**NSW P&E Ref: 8\_0167 Belle O'Connor St****08\_0167 MOD2, Modification to Residential Subdivision - 08\_0167 MOD 2**

26 May 2017

**RE: Section 75W Modification of Consent – Stage 10 and 11 of MP 08\_0167  
Lot 36 DP 1214499 Belle O'Connor Street, South West Rocks.**

Title:  
**GENERAL ARRANGEMENT  
& LOT LAYOUT PLAN**

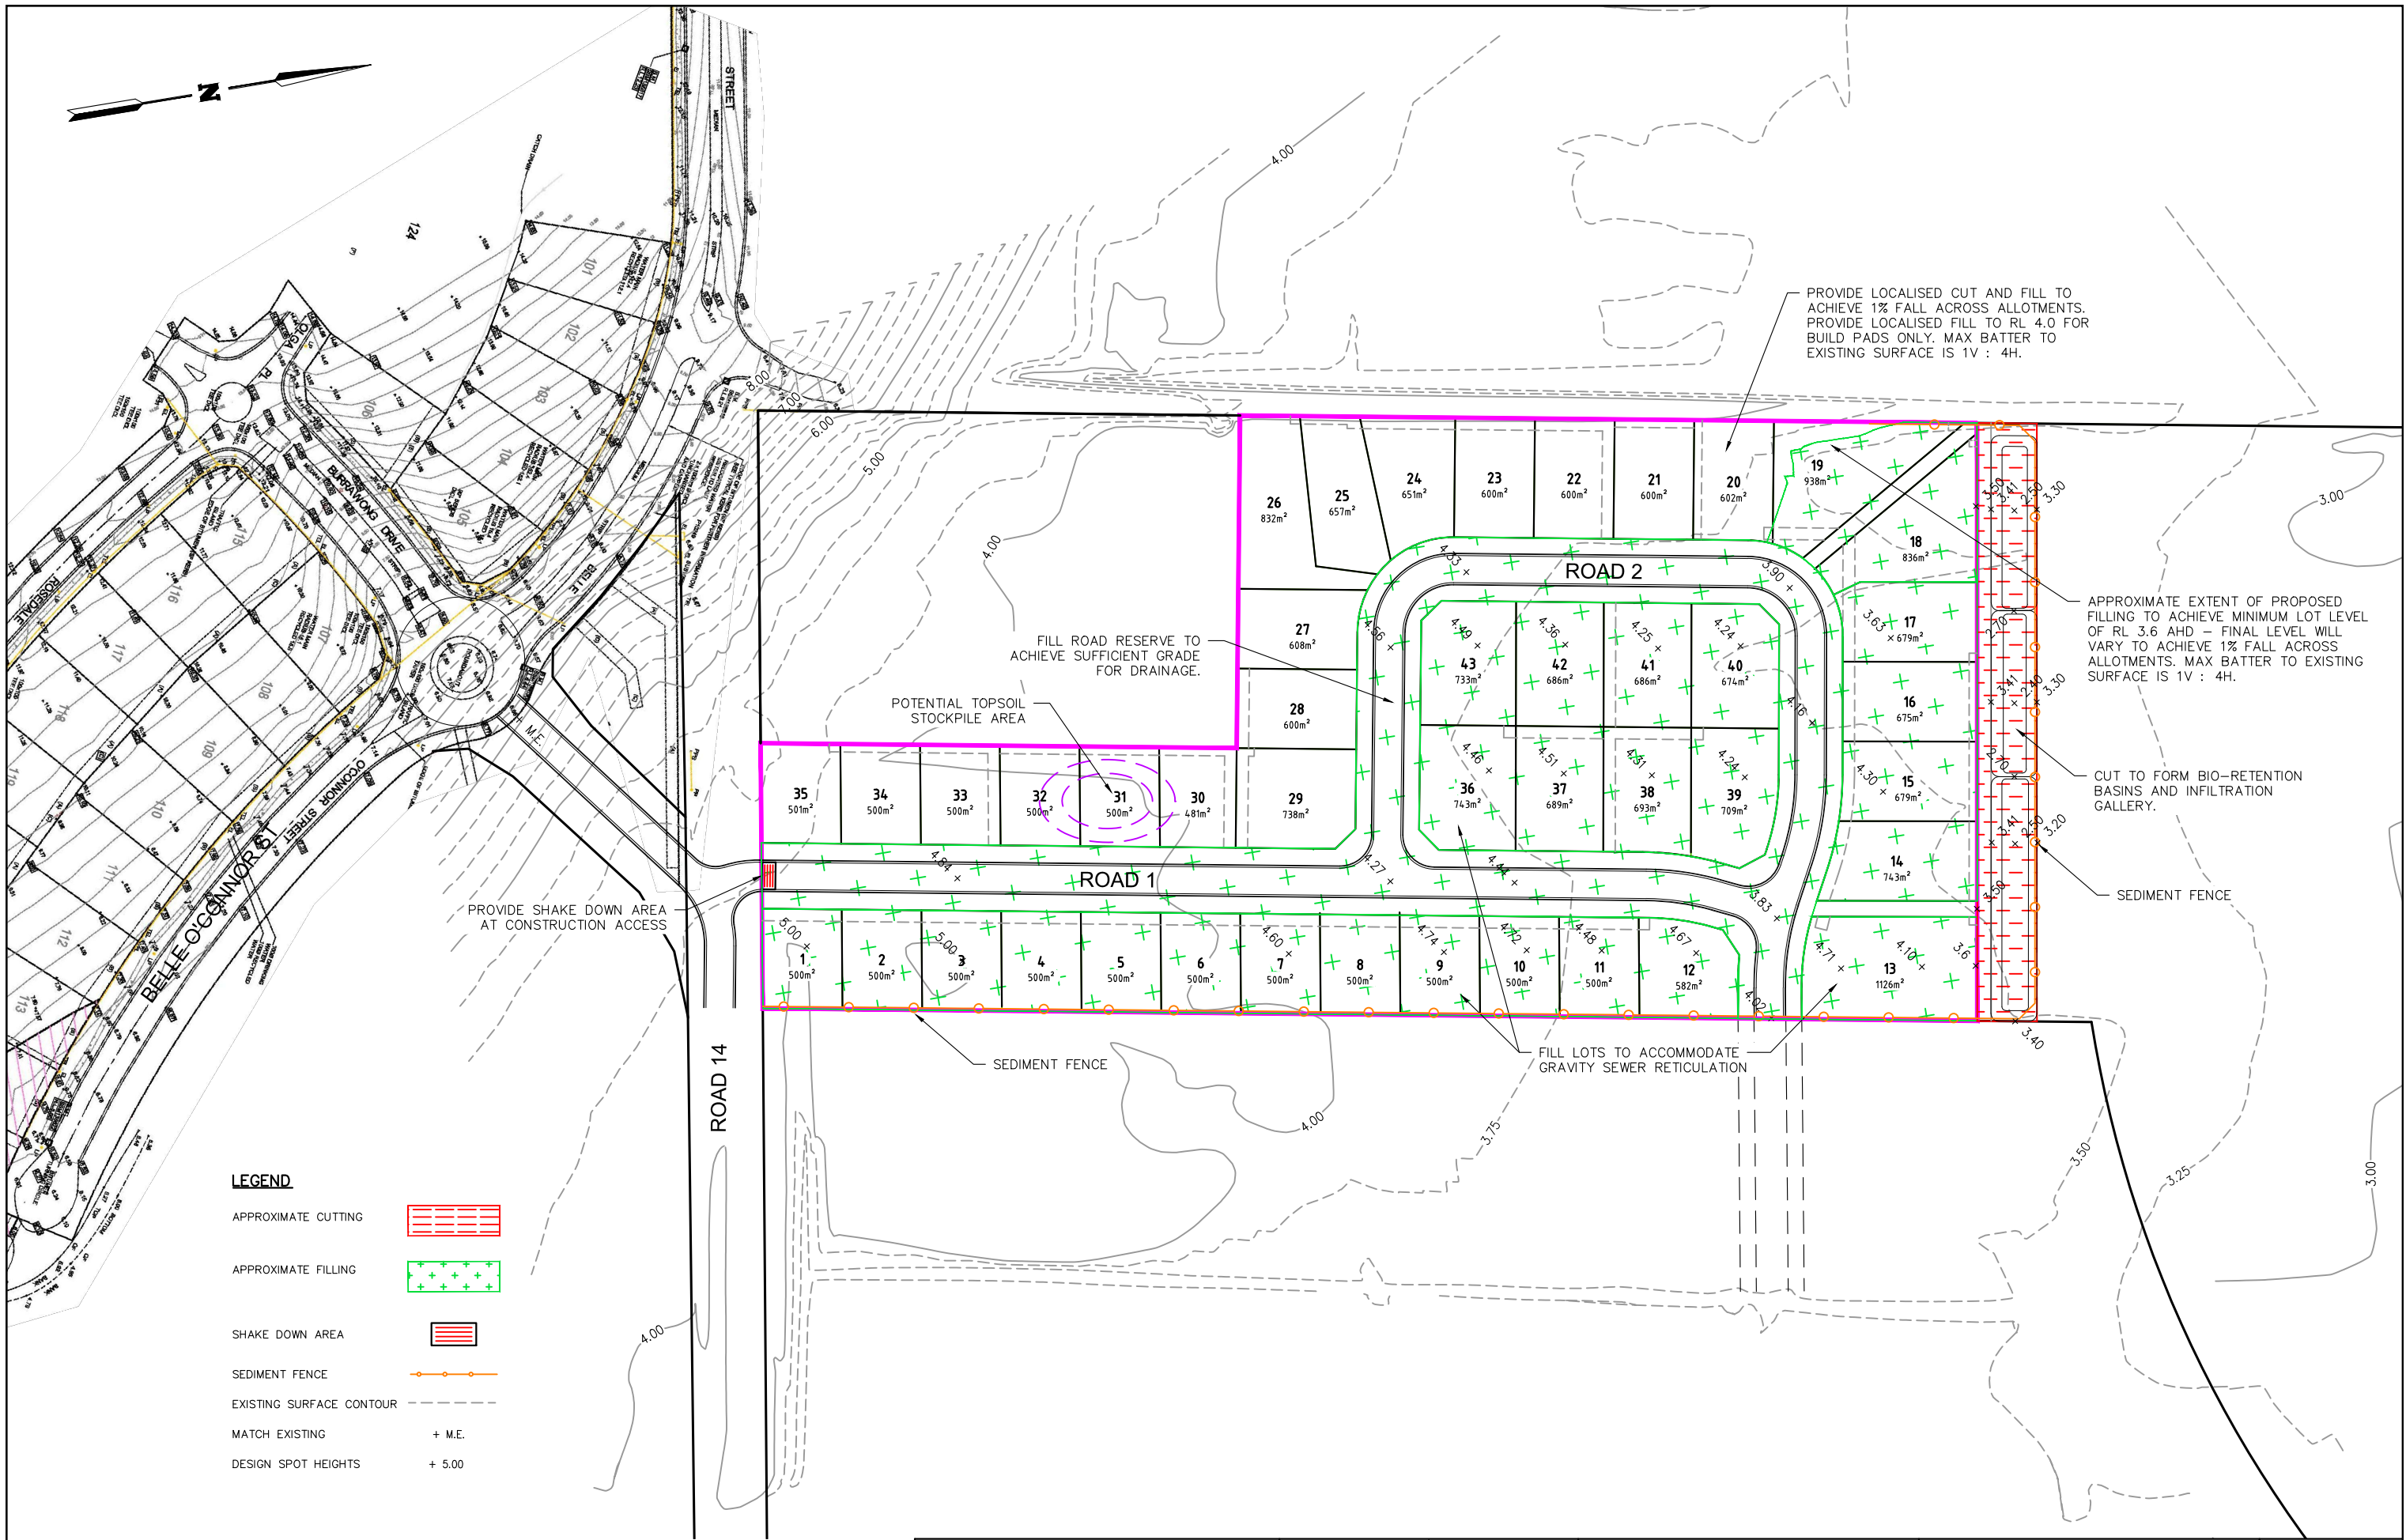
**Access to each of the ‘developments’**

### **Adequacy and integration of the overall road network**

As shown in the Engineering drawings, public road access to proposed Lots 1 to 43 will be via a new public road connection off the Belle O'Connor Street / Burrawong Drive roundabout.

This new road connection intersects with Road 14. Road 14 serves the remaining stages of the Malbec development.

The proposed extension of Burrawong Drive will have no detrimental impact on the ability of the remaining stages of the Project Approval to proceed as approved and modified.

As stated above, Road 14 serves the remaining stages of the Malbec development. Proposed Road 14 is the main connection to Belle O'Connor Street. The proposed modification does not jeopardise the approved road layout in any way.

As shown in the images below, (dashed black circle), the proposed layout retains a local road connection from Lot 36 to Stage 9 of the approved development.

STORMWATER MANAGEMENT

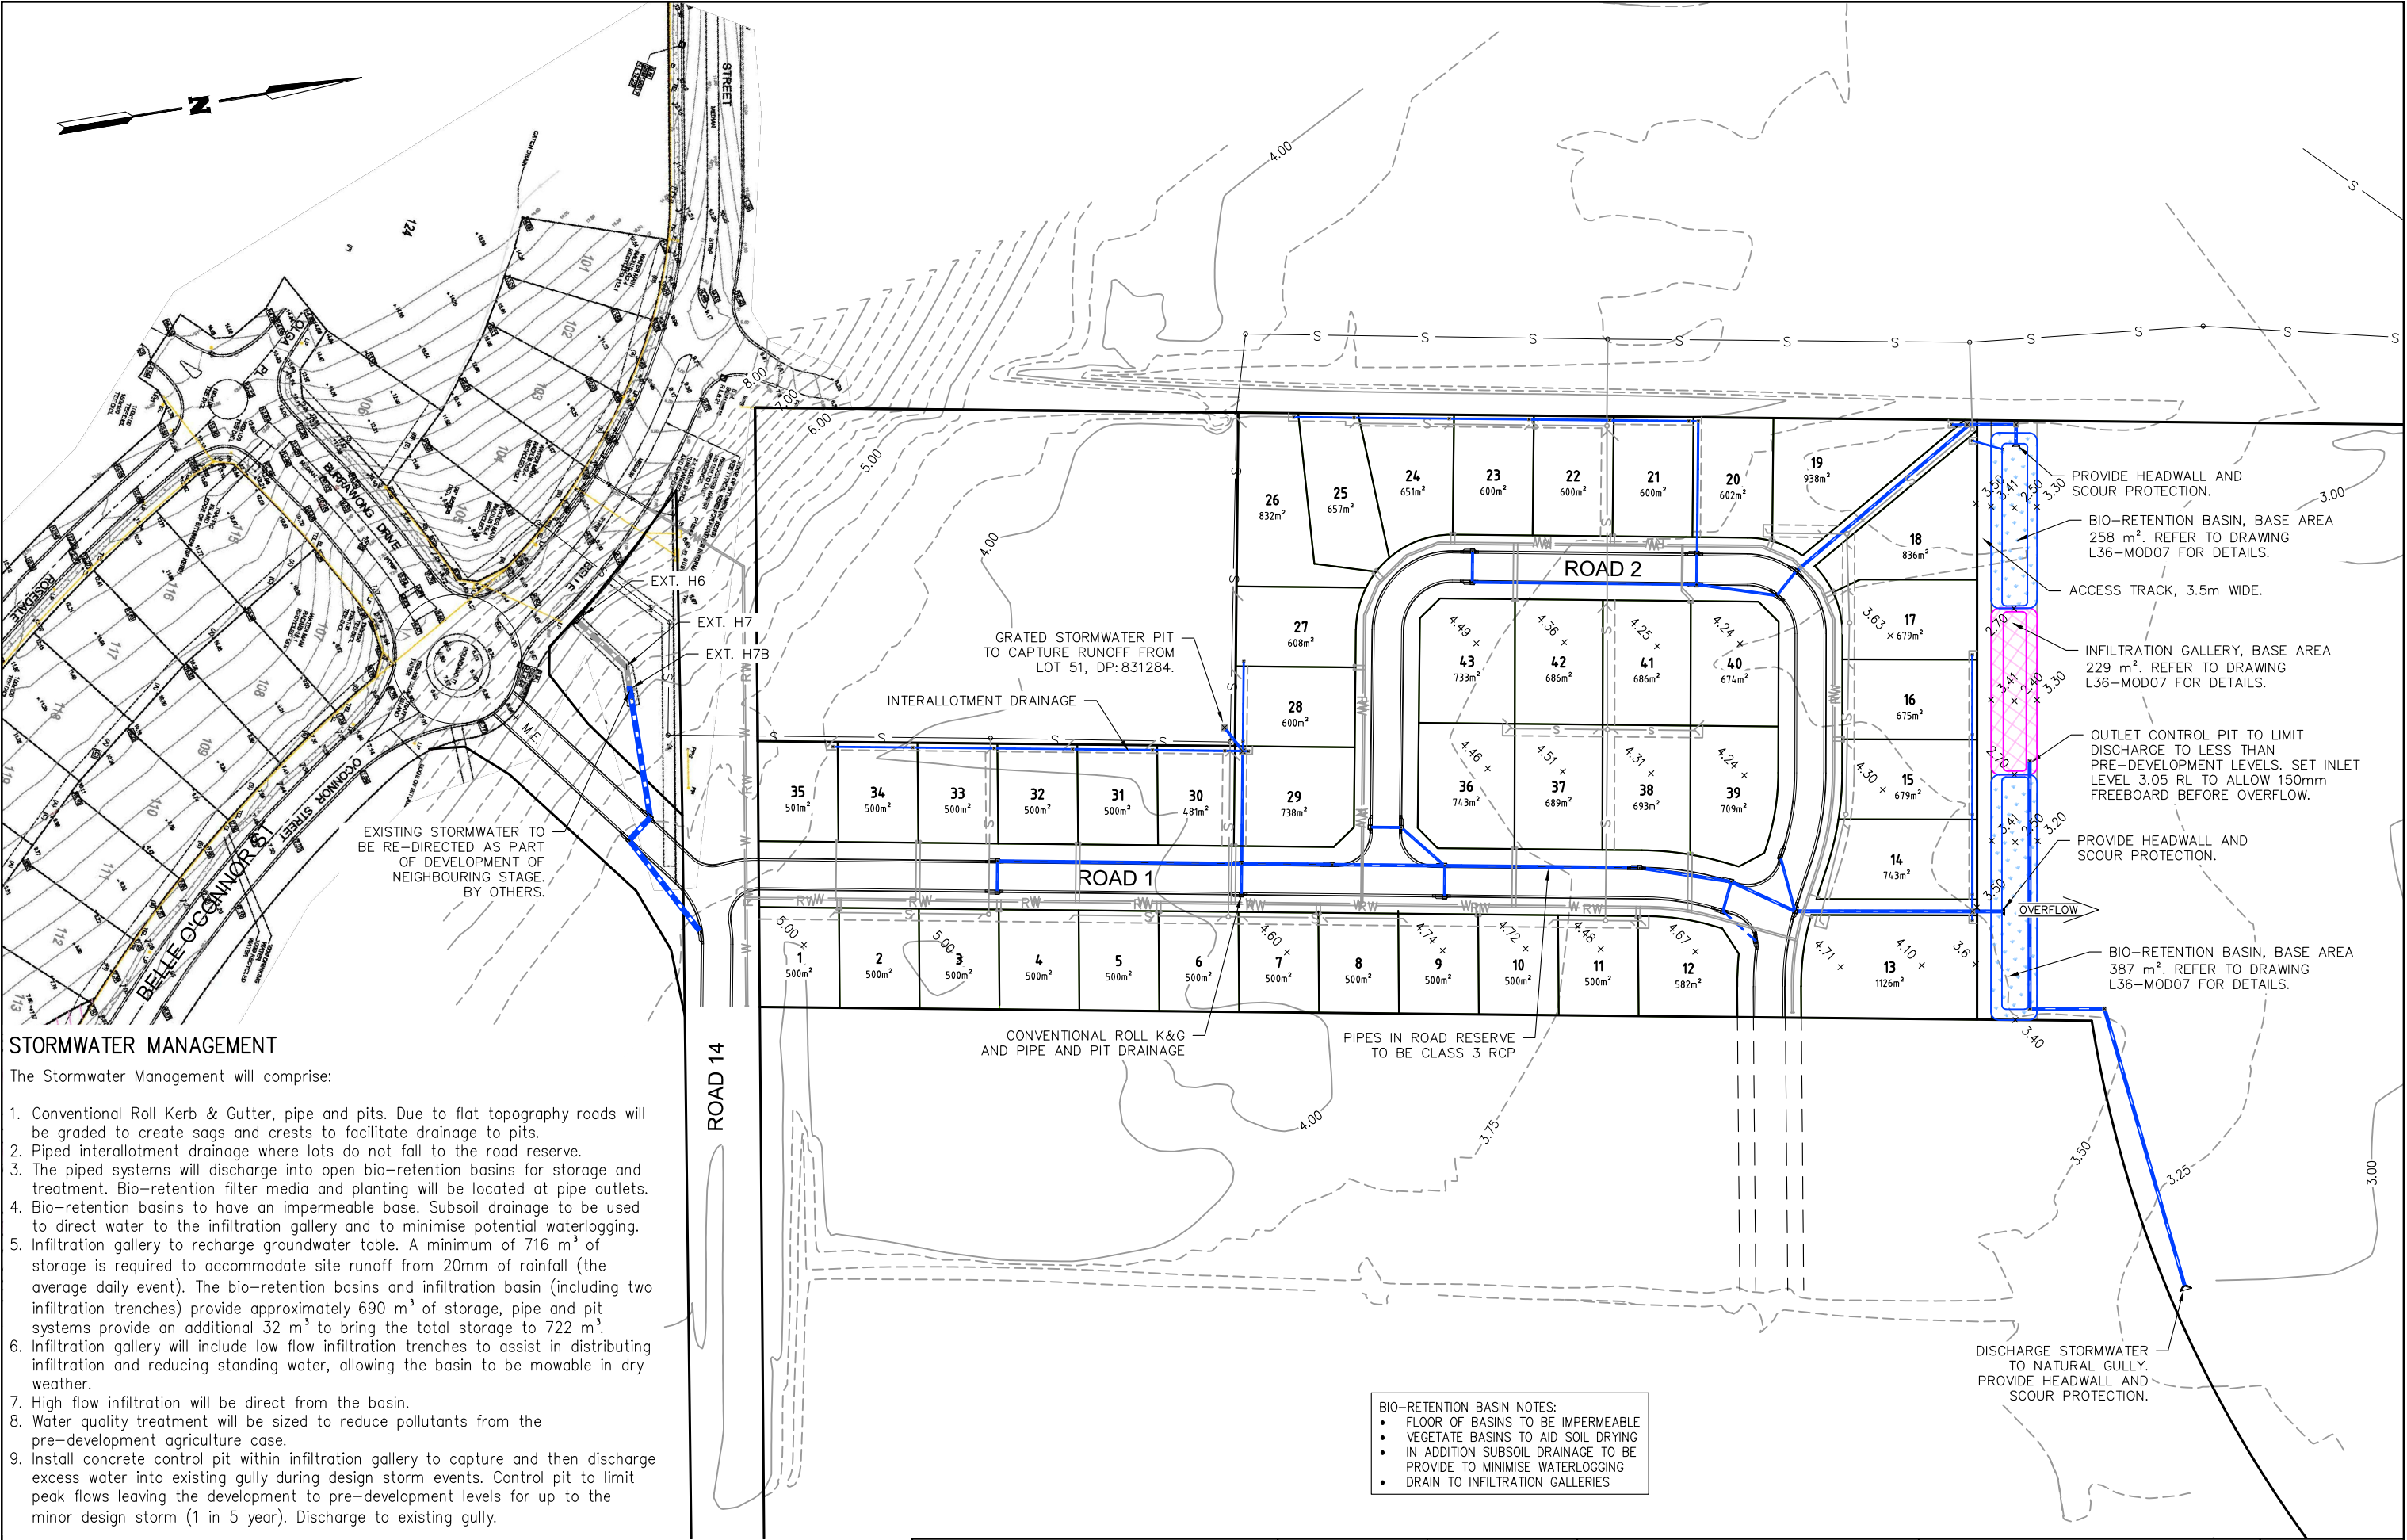
***Appropriateness and integration of the different stormwater management systems proposed.***

***c) Stormwater management infrastructure for Lot 36 is proposed on the adjoining and separate Lot 35. Whilst at present the two parcels are under the same ownership, how will this be addressed should this not be the case in the future?***

The proposed stormwater drainage management system for Lot 36 will function independently of the system proposed for Stage 1 to 9 of the Project Approval. The main elements of the proposed system are:

- Water collected within the developed site is to be drained to bio-retention basins for treatment.
- The proposed bio-retention basins are to be lined with filter media and selected plantings.
- The bases of the basins are proposed to be impermeable and sub-soil drainage to be used to drain to the infiltration gallery to avoid waterlogging.
- The proposed infiltration gallery is to recharge the groundwater table.
- The bio-retention basins have been sized to suit the deemed to comply WSUD solutions.

As shown in the Engineering Issues Report and Drawings 13056-L36-MOD04-DA1 and Drawing 13056-L36-MOD07-DA, there is no requirement to integrate the two systems.

A bio retention basin will be located within the existing Easement to Drain Water 15 wide created by DP 1214499. This easement was created to benefit Lot 36.

The stormwater infrastructure (pipe outlet and grassed swale) is wholly located within Lot 36 and the drainage easement over Lot 35.

The stormwater management infrastructure will be wholly located within the Easement to Drain Water 15 m wide created by DP 1214499. As stated above, Council issued a Subdivision Certificate for DP 1214499 inclusive of the creation of the drainage easement over Lot 35.

The stormwater infrastructure works will be located within an already cleared area at the boundary of Lot 35 and Lot 36 DP 1214499. The stormwater swale will be vegetated as shown in Drawing L36-MOD07 – refer extract below.

Consistent with the Project Approval, this 15 m wide strip of land will be used for fire trail, cycleway, native grass planting and the stormwater swale.
